Amended Proposed North Elevation

(Please Compare to Approved Document 19DA-PE-001 / Rev 1)

DRAWING NO.
 19DA-PL-02-NE

Project
New Build
19 Downs Avenue

Project: Detached New-Build Home 19 Downs Avenue, Epsom KT18 5HQ	Drawing Title: Proposed Site Plan Drawing Number & Revision: 19DA-SP-001 / Rev 1	Details: Scale: 1:200 and 1:100 Paper: A1
---	--	---

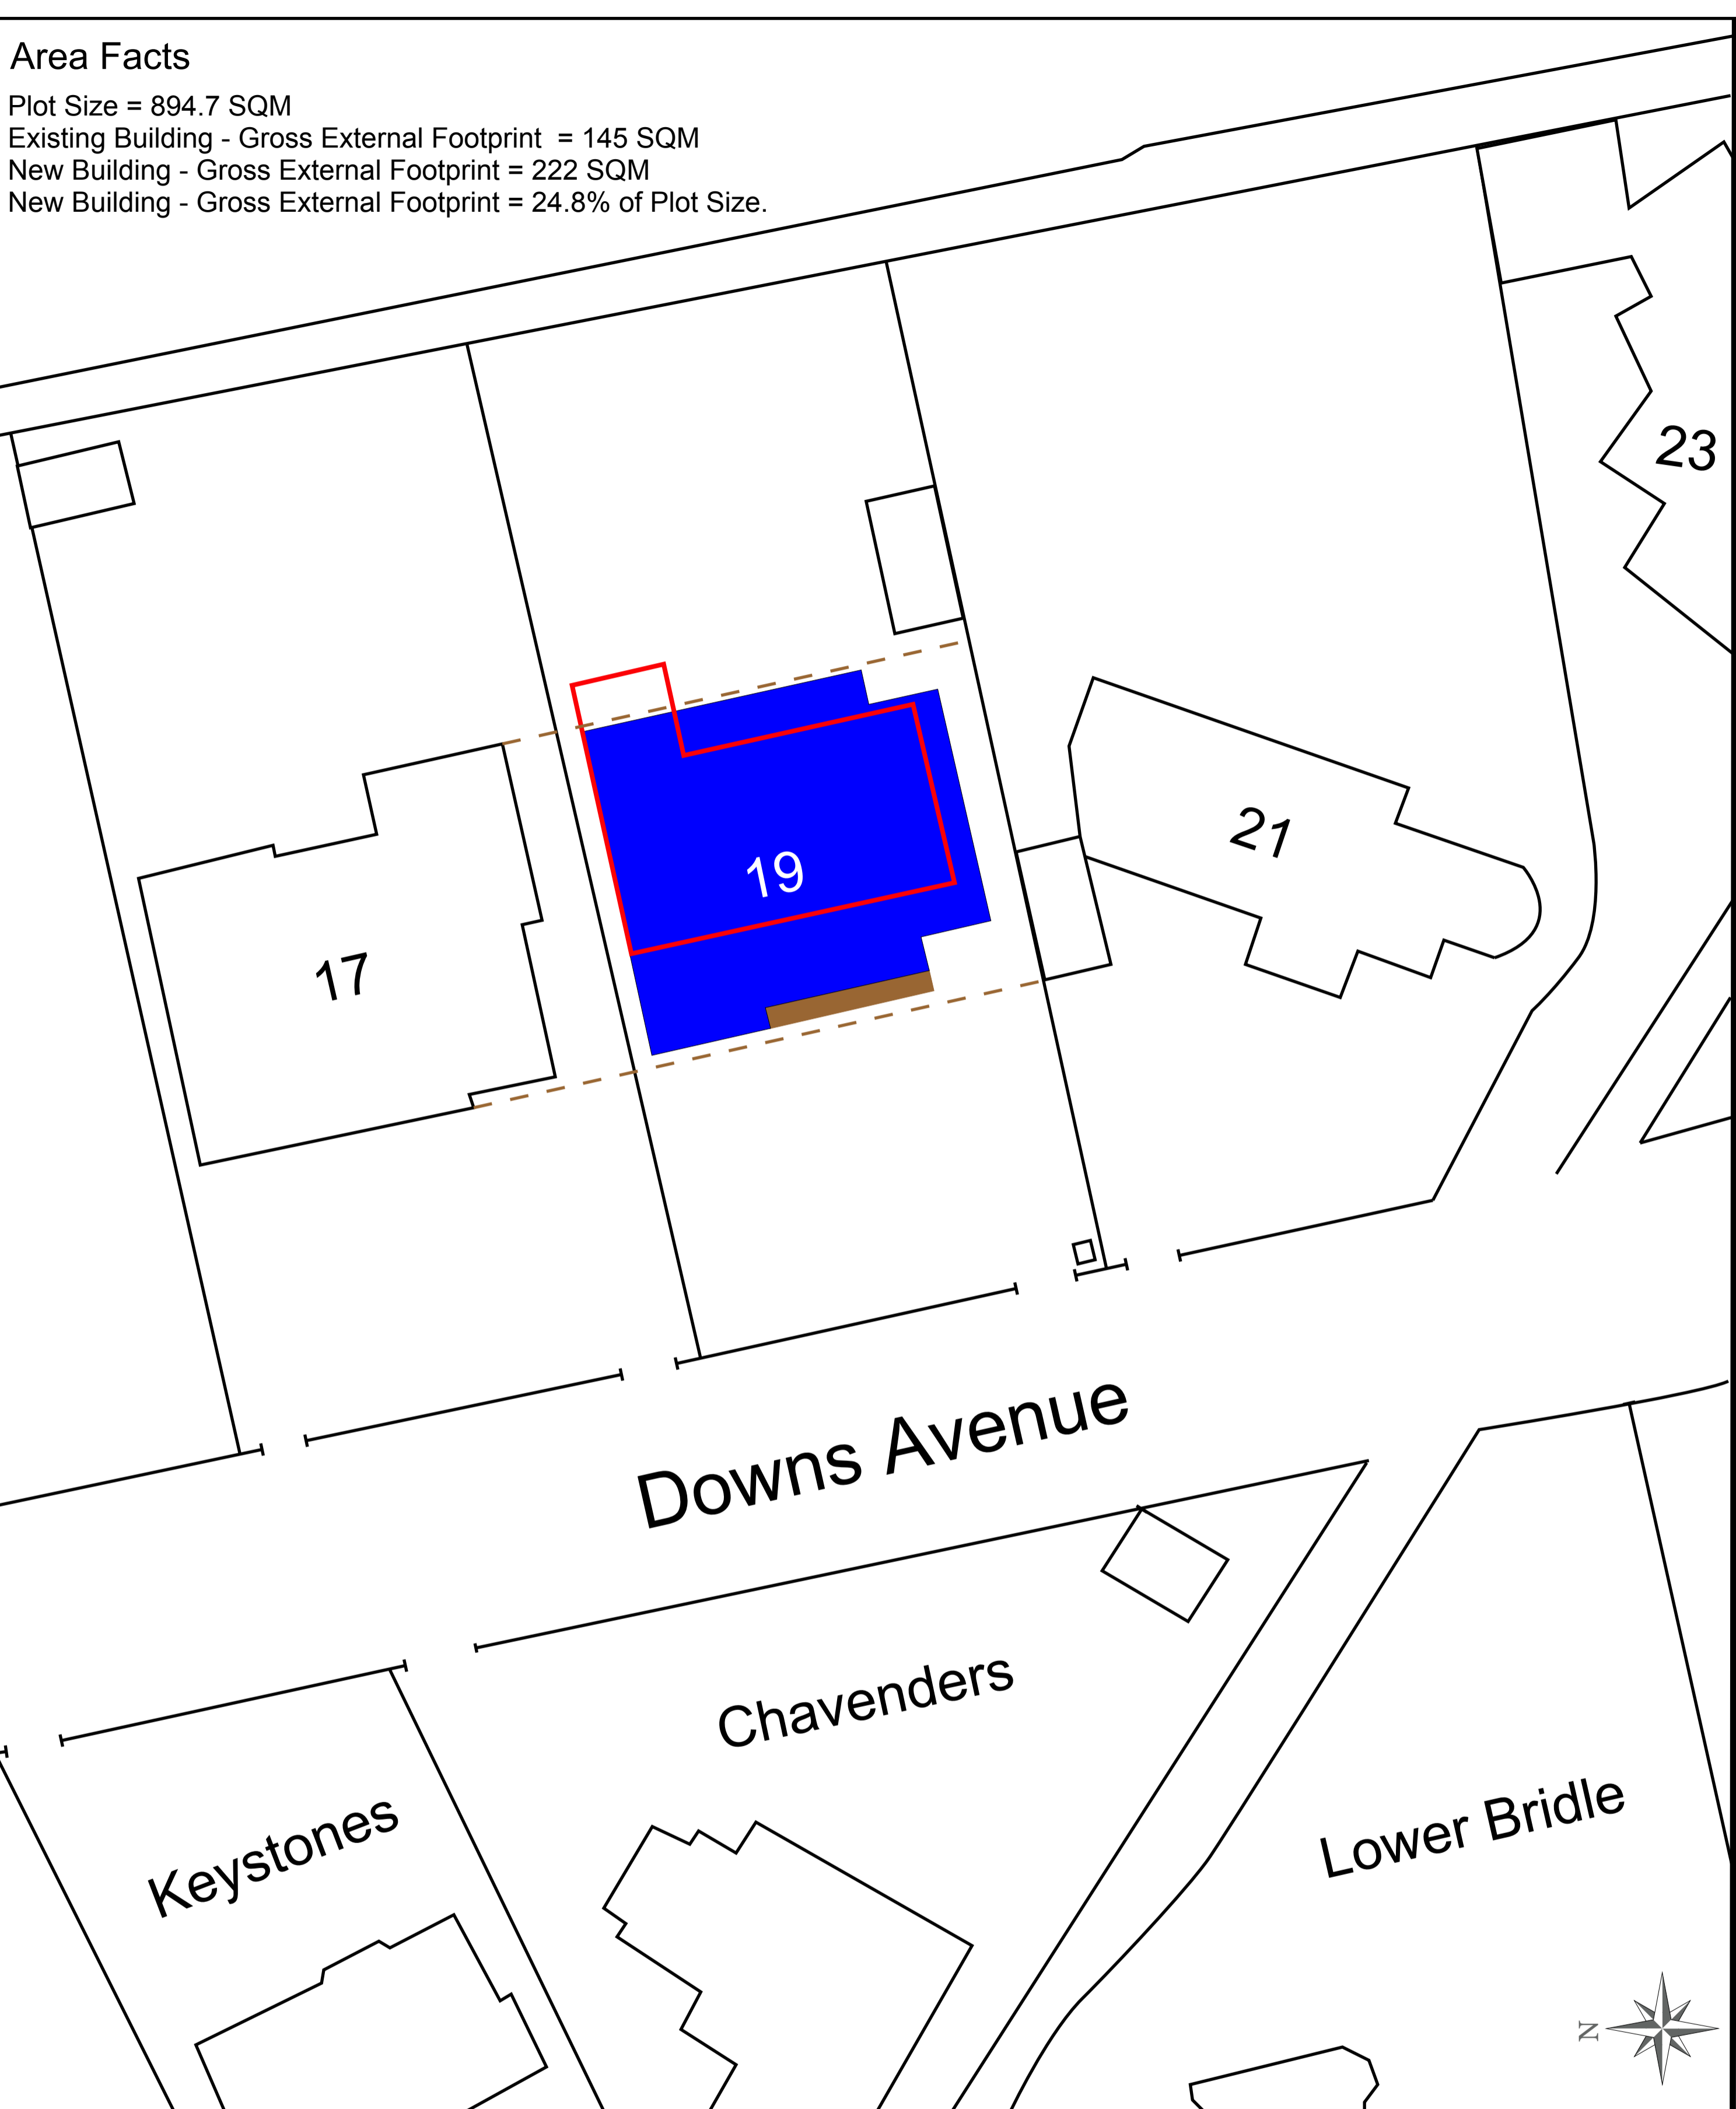
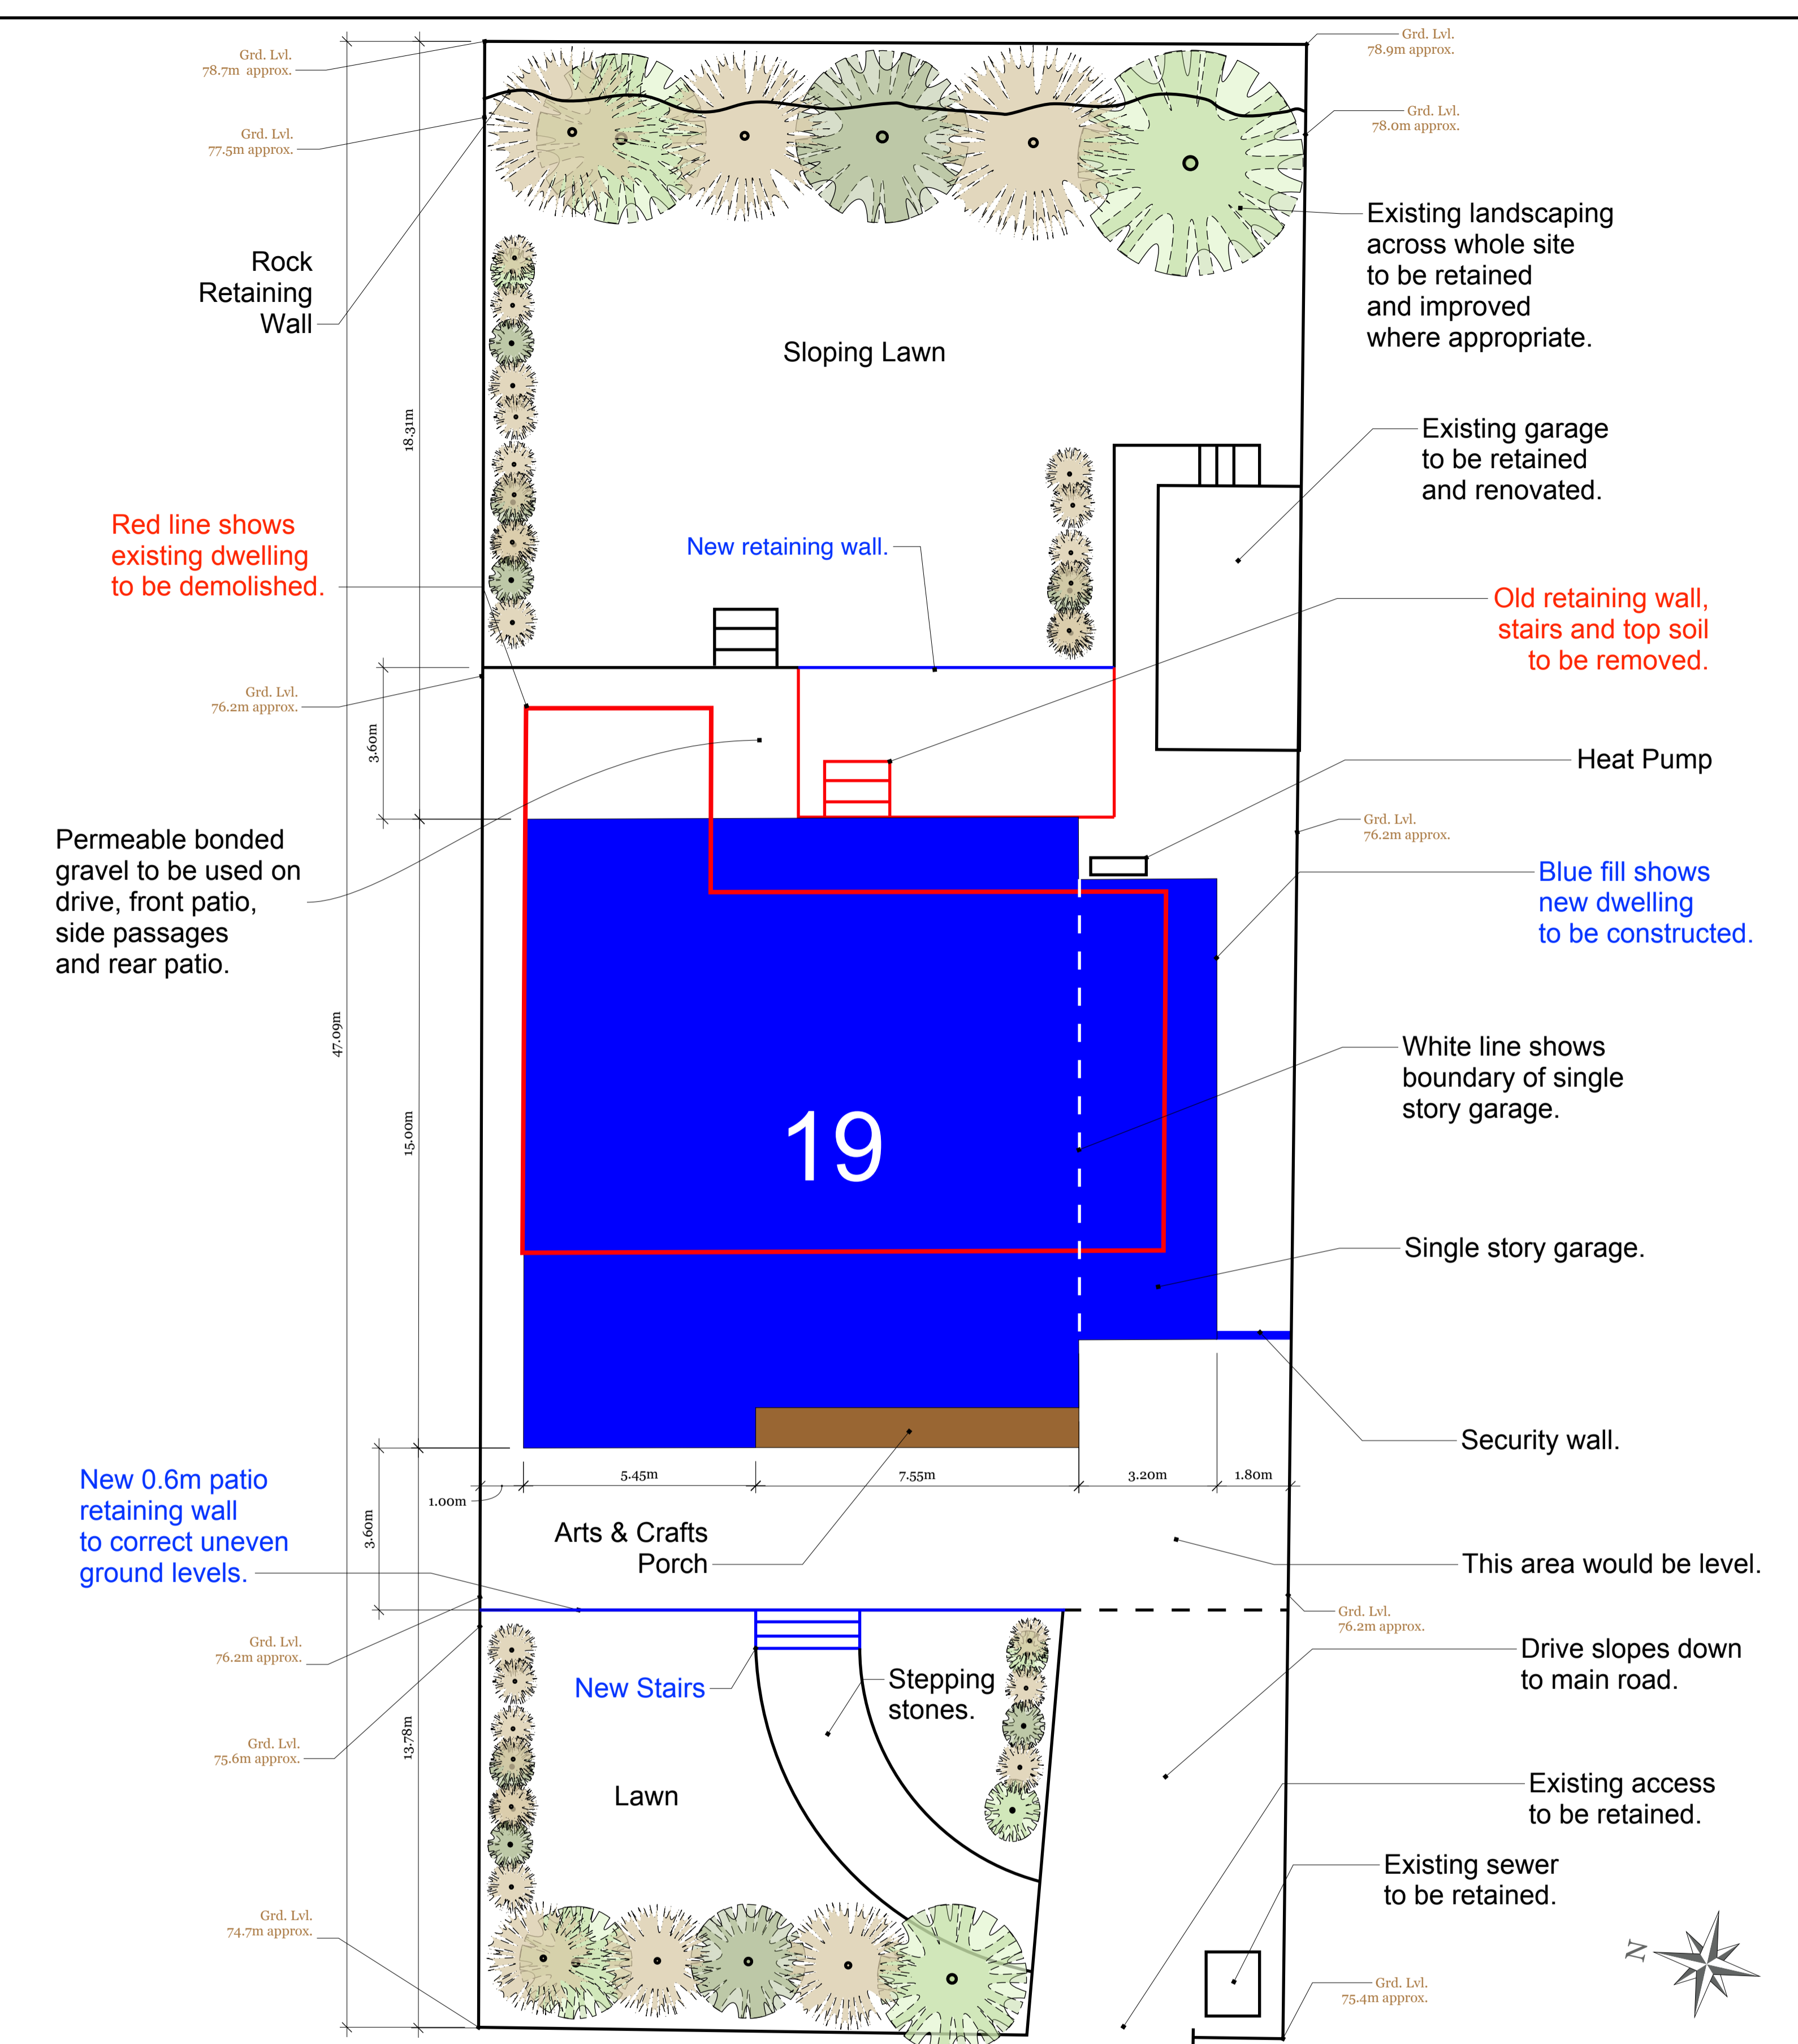
In response to privacy comments in [1] this walkway has been reduced from 3.6m to 1.6m and will no longer be used as a patio.

Instead, we propose that we build a 3.6m patio at the edge of the lawn.

Drawing Title:
Existing / Proposed Street Scenes

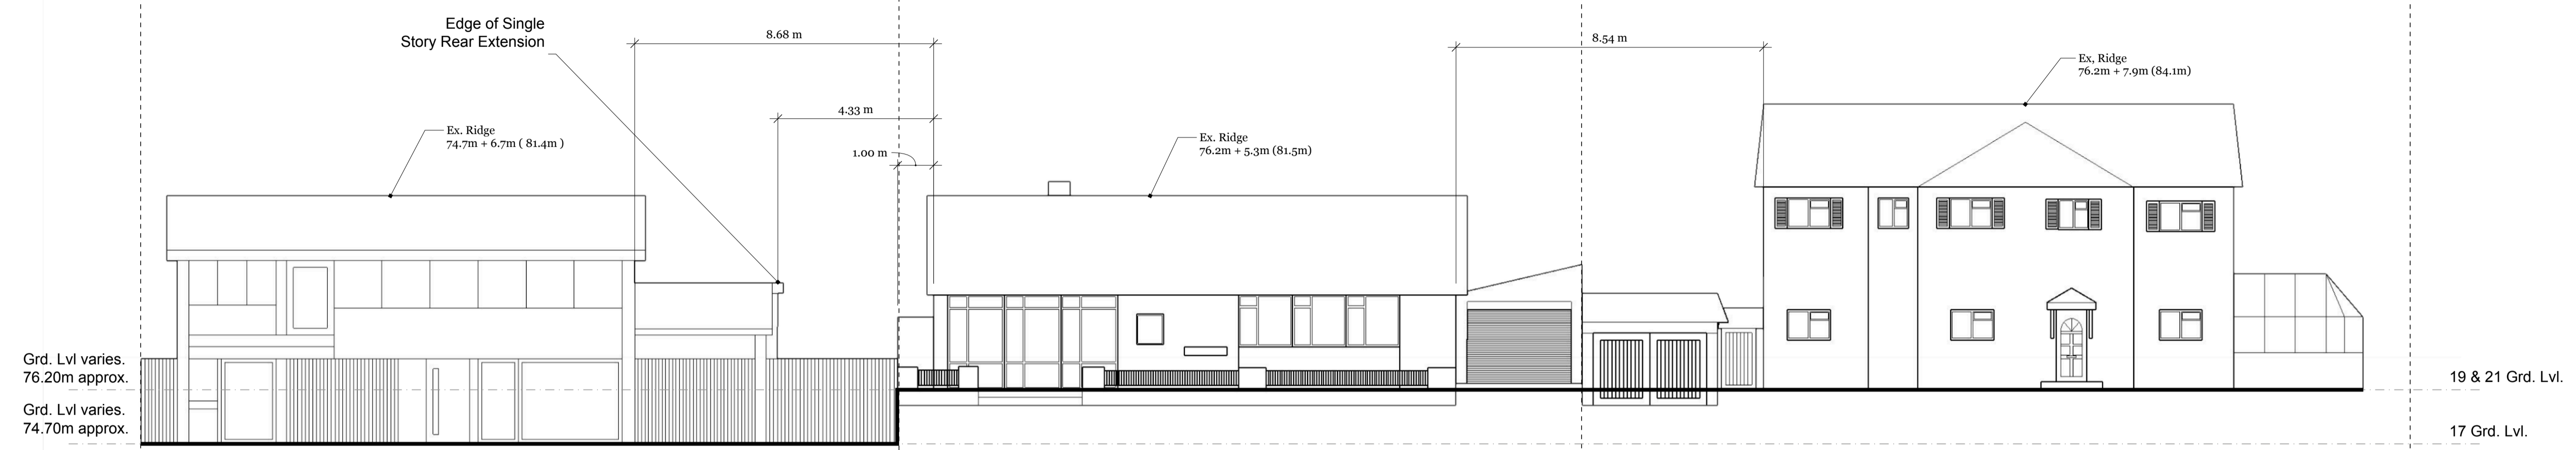
In order to increase the amount of natural light reaching number 17, we are interested in transitioning to a hipped roof design.

To improve the aesthetics of the building we would like to clad the first floor walls: (front, back and both side elevations) with tiles. In the current design only the front gable is clad and the remaining walls are brick.
